## Engineers Comments Regarding Surface Water Drainage

| Application Reference:   | <b>FP/65/26/HH</b>                           | Reviewer Reference: | ADC/KW/PC  |
| Site Name:               | 6 The Loop Felpham PO22 7ND                  |                     |            |
| Application Description: | Detached double garage, new gates and piers. |                     |            |

© This drawing is the copyright of Robert Clark BSc CEng MICE It may not be copied or reproduced without his written authority			
Scale As shown		At original A3	
Drawing Number 2161/D1		Revision -

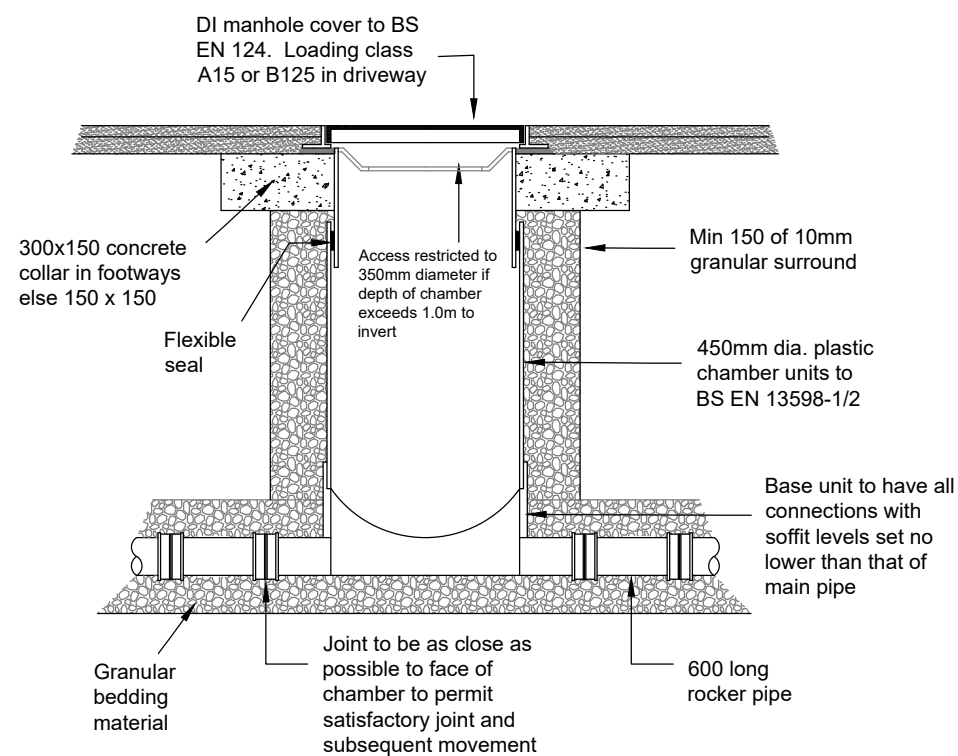
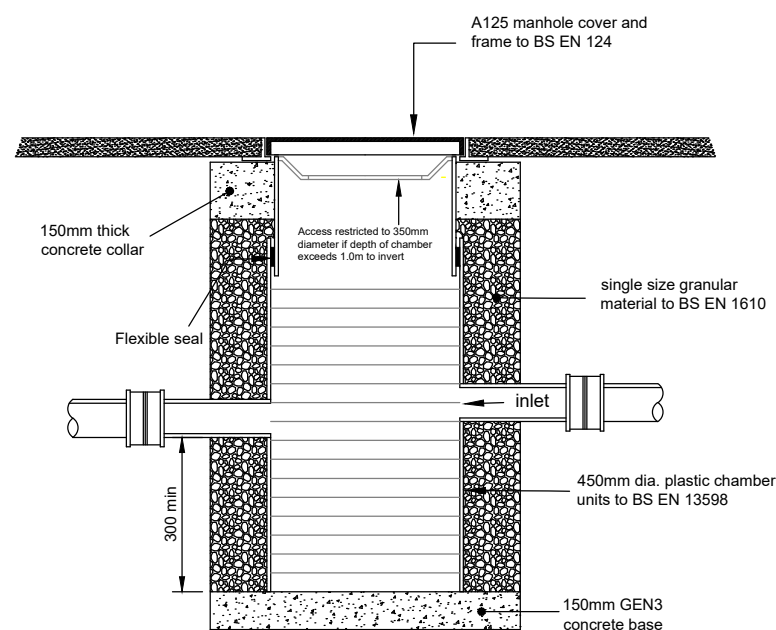
- 1.4. In order to 'make best use of soakage and accord with good SuDS principles', the attenuation tank has been designed as an unsealed system to allow for some degree of infiltration into the ground. However, infiltration has been demonstrated to be unviable in terms of the NSfS, as it fails to achieve the one metre freeboard. This feature should be revised to a fully sealed system.

7.1. A 20mm orifice is proposed to restrict flow into the pond. Due to the minimal diameter, we require this to be robustly protected (by design) from risk of blockage.

© This drawing is the copyright of Robert Clark BSc CEng MICE It may not be copied or reproduced without his written authority			
Scale	As shown	At original	A3
Drawing Number	2161/D2	Revision	-

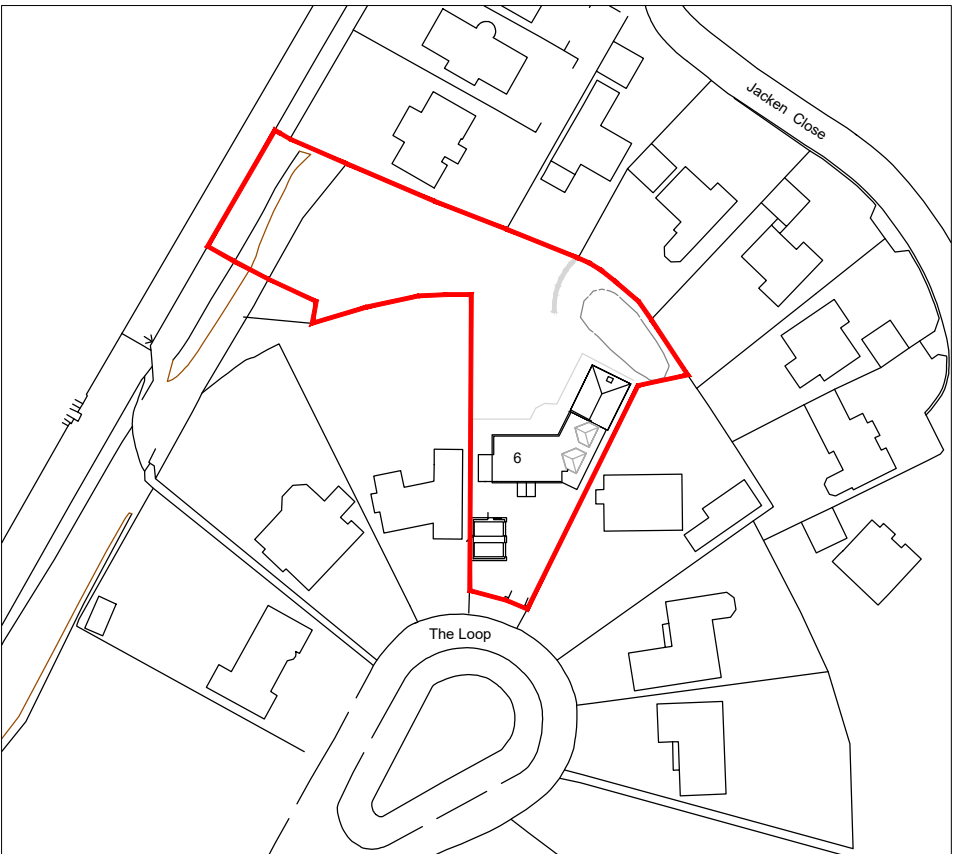
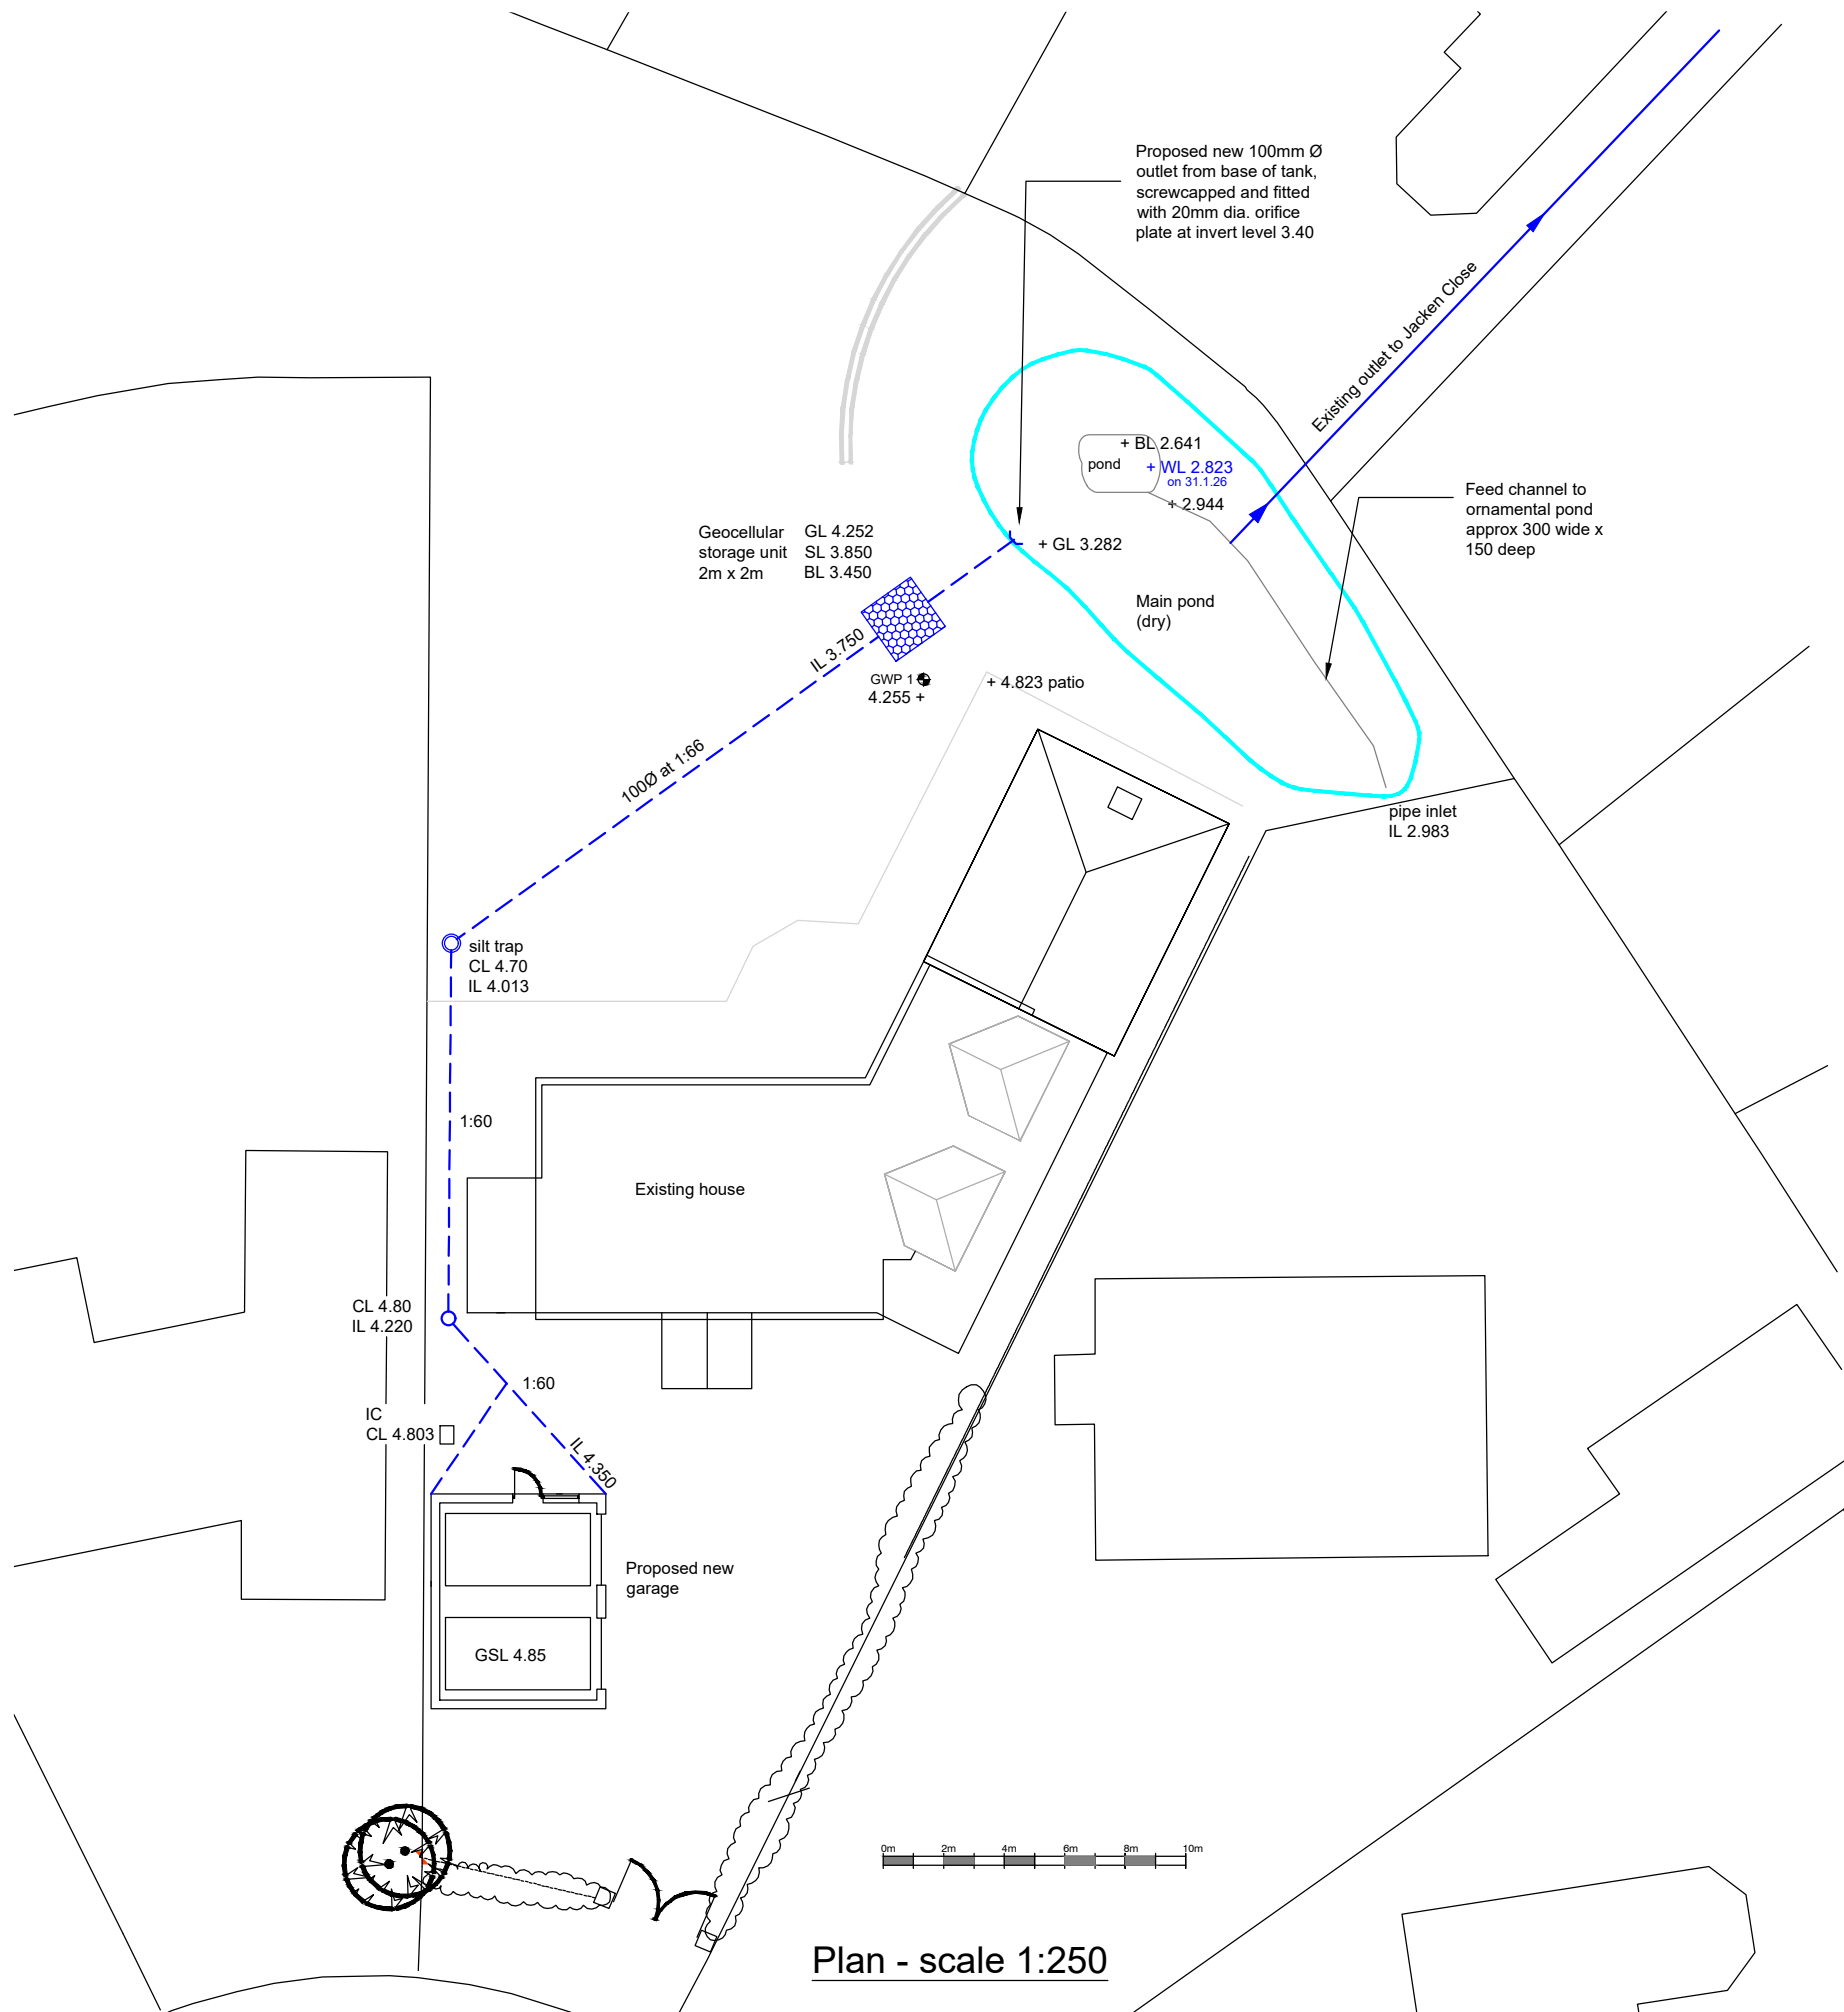
- 1.3. It is noted that Plan 2161/D2 denotes this pond (or at least part of it) as ornamental. The applicant is reminded that the pond is an important feature of the existing surface water/land drainage drainage system in the immediate area, receiving flows from the north.. Any implication that the pond is not an important component of the area's surface water drainage system should be removed from the plans.

- 1.7. Details of the pipe diameter and gradient for the section of pipe between the attenuation tank and the headwall are also required and should be shown on the plan to ensure self-cleaning velocities are achieved.

- 2.1. Water butts are proposed, please demonstrate these on plan. In recognition that the National Planning Policy Framework states that SuDS should be proportionate to the nature and scale of the proposal we are willing to accept that the following interception features can demonstrate compliance without further detailed assessment.
